File: SF17/1251  
Job ID: DOC17/467221

**RE: Notice of Exhibition – Concept Development Application (Staged Development) for alterations and additions to the Intercontinental Hotel and Transport House (SSD 7693)**

**Katrina Stankowski**  
 Manager, Listings  
 Heritage Division  
 Office of Environment & Heritage

SETBACK DIAGRAM | VIEW FROM NORTH-EAST

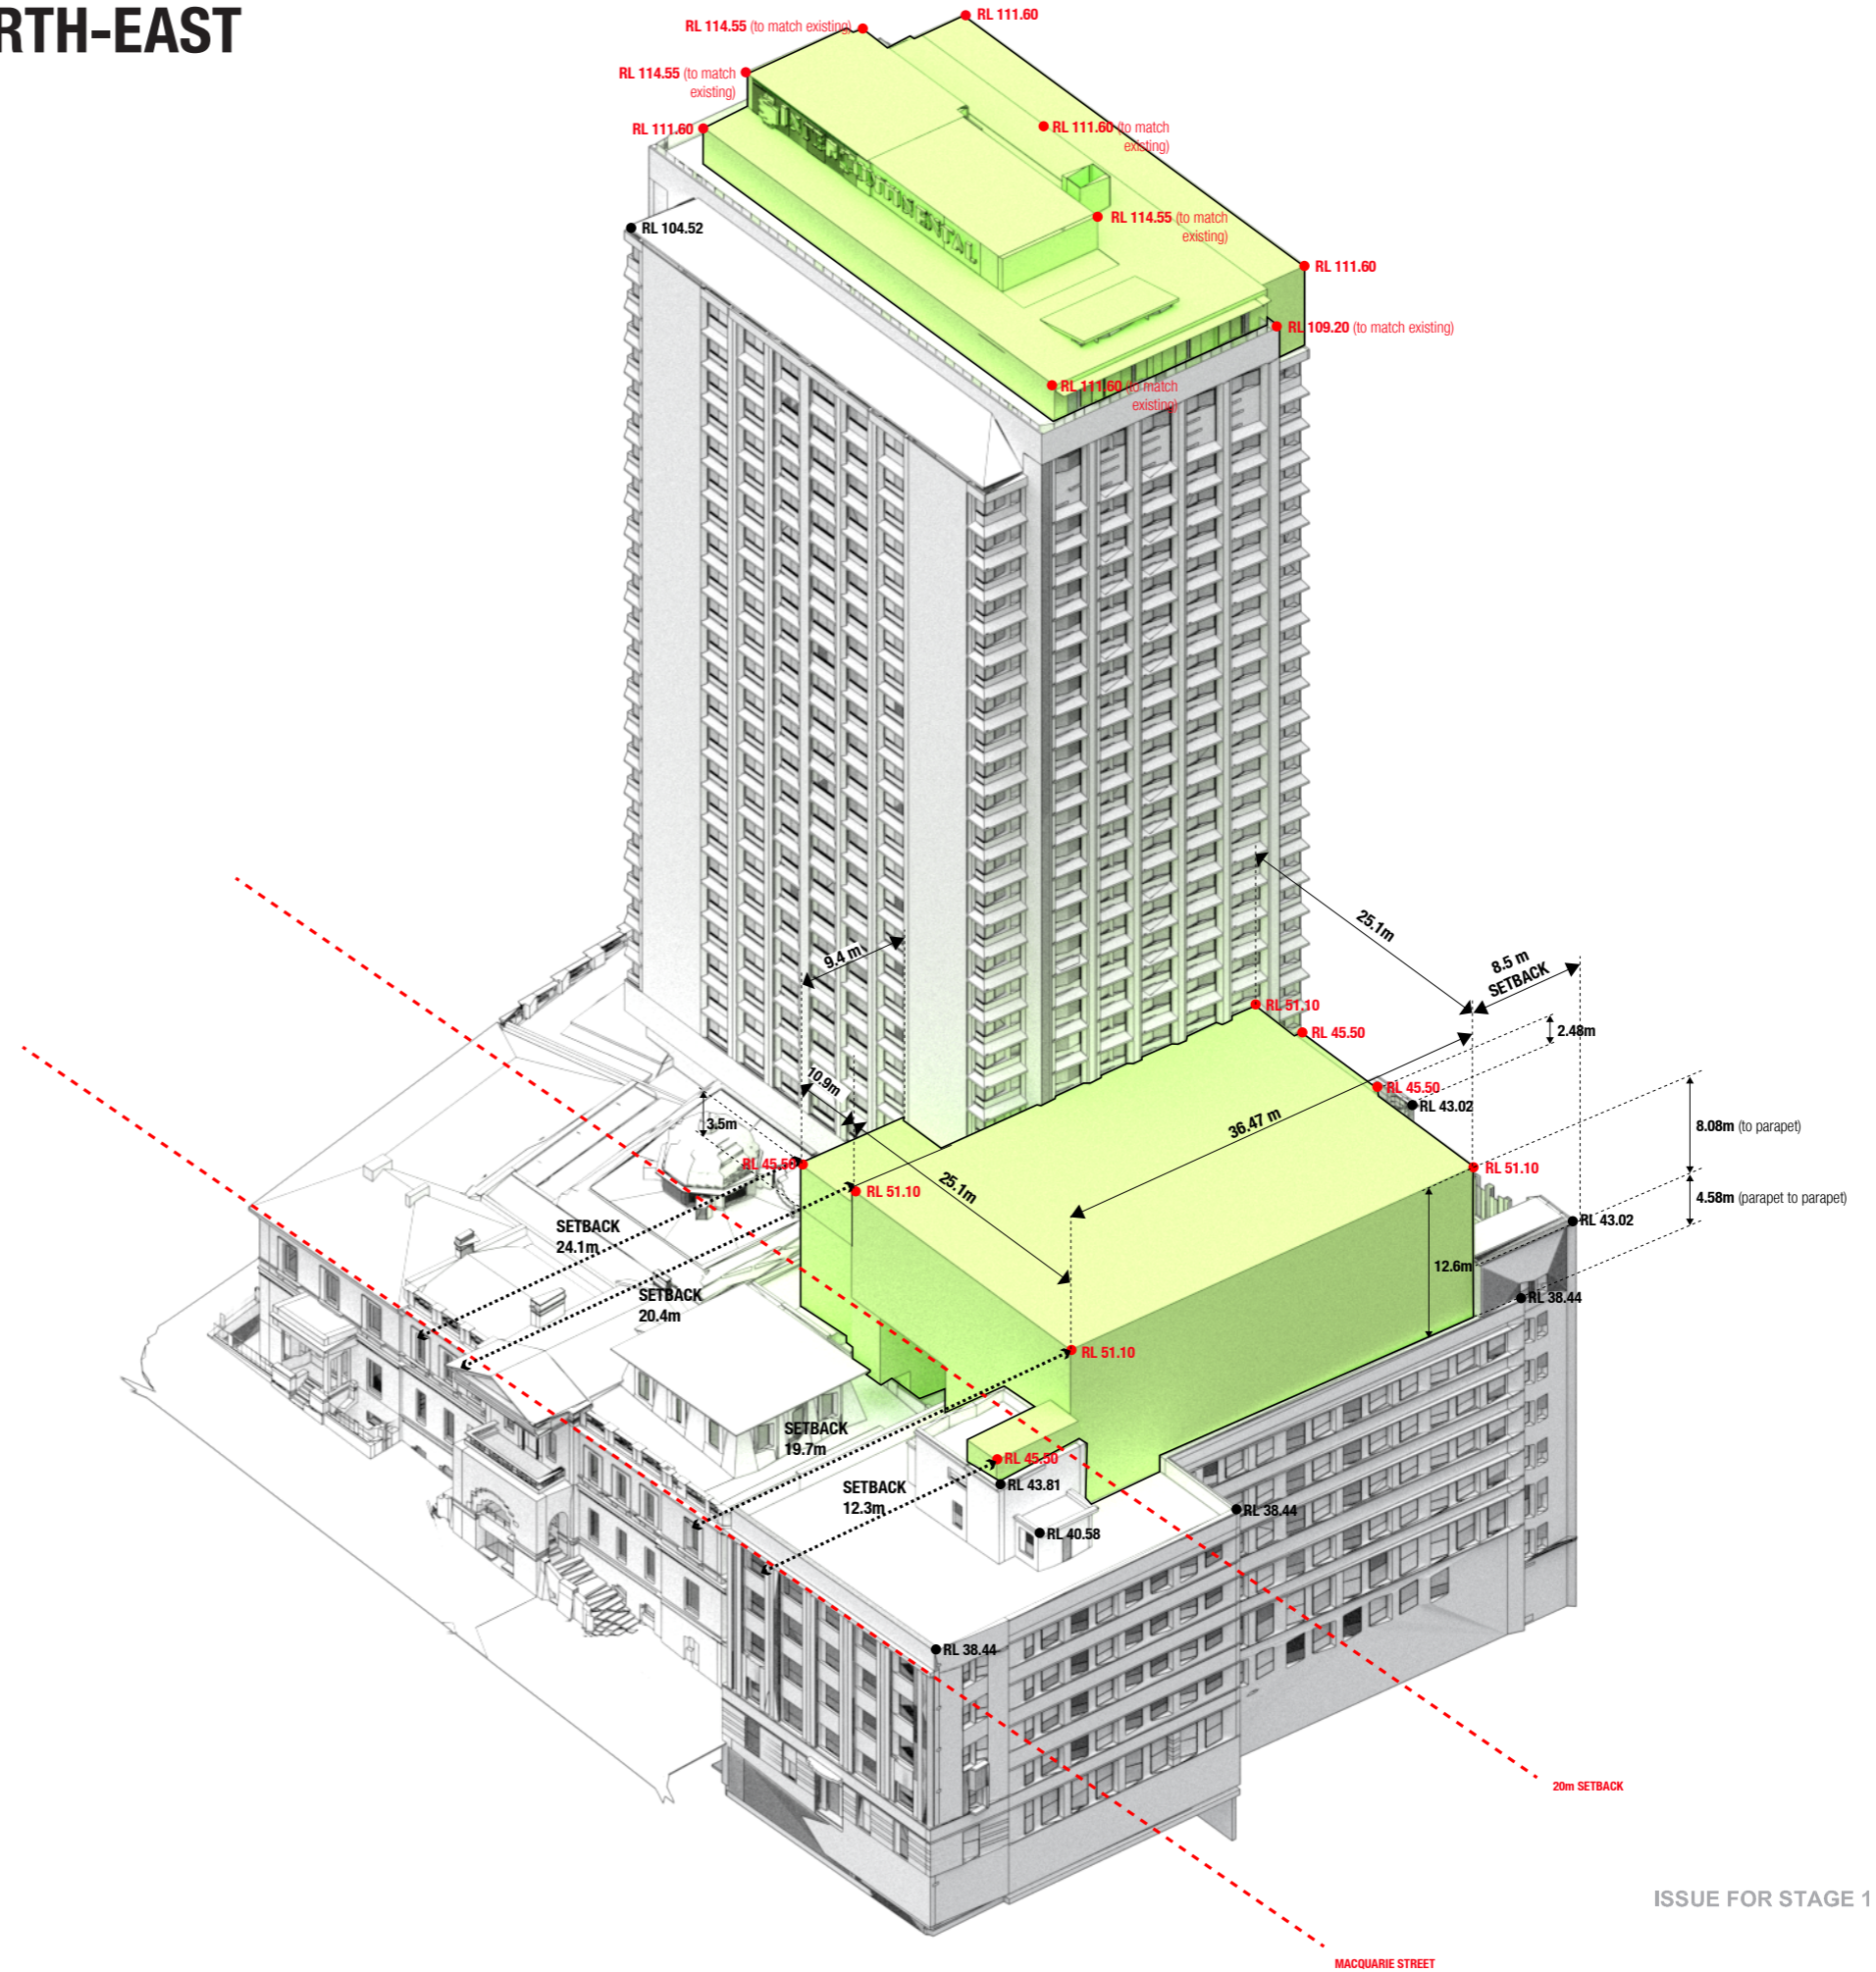
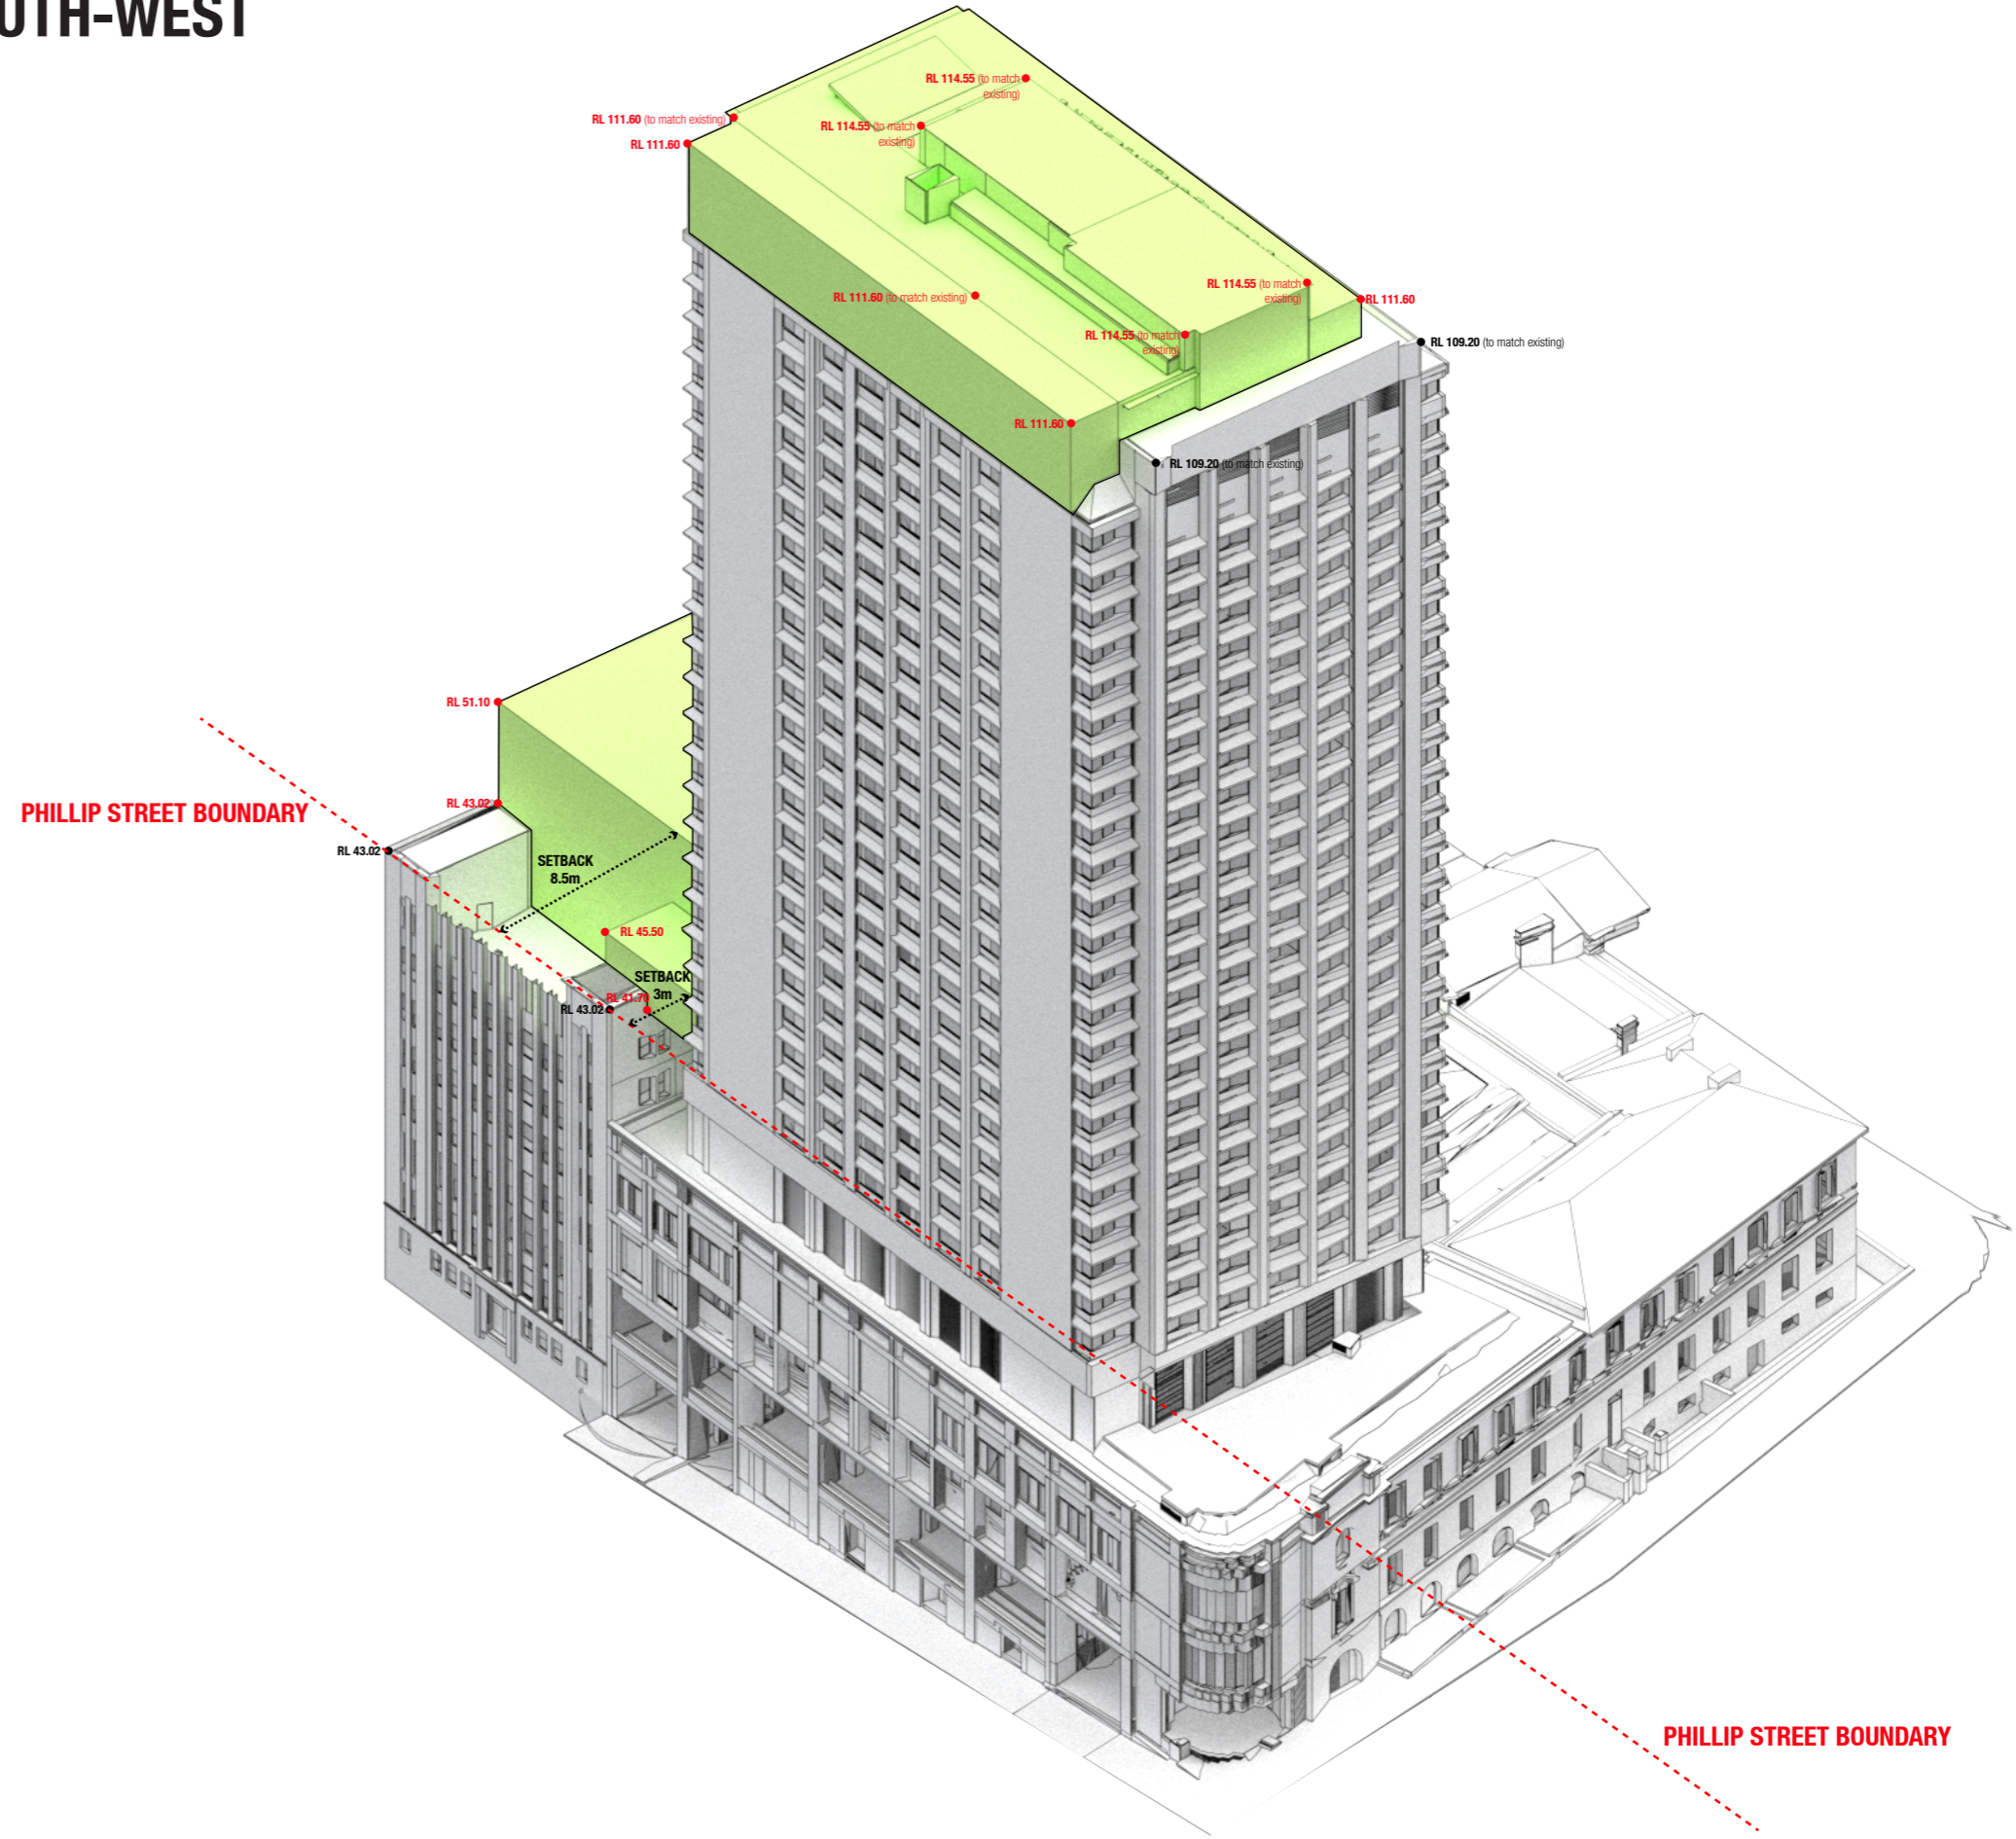
- A schedule of conservation and restoration works to significant spaces and elements of the heritage buildings should be prepared and submitted as part of the Stage 2 SSD application.
- The scale and form of the rooftop additions to the 1980s podium building should be reconsidered and reduced to mitigate visual impacts on the setting of the affected heritage items including SHR listed former Treasury Building.
- The proposed external refurbishment of the hotel tower that is located behind and above the former Treasury buildings should be carefully designed with input from the nominated heritage consultant, to ensure that the final design in terms of materiality, reflectivity and colour mitigates the existing impact of the structure on the heritage buildings and other heritage items in the vicinity by enhancing the setting of these items.

The proposed form of the addition above the roof-top of the locally listed Transport House should be reconsidered and setback from the building's facade along Phillip Street to minimise visual impacts. The HIS states that the roof top addition can be achieved without significant intervention into the building. It is recommended that documentary evidence be provided by a Structural Engineer, with experience in heritage buildings, confirming the findings of the HIS in this regard.
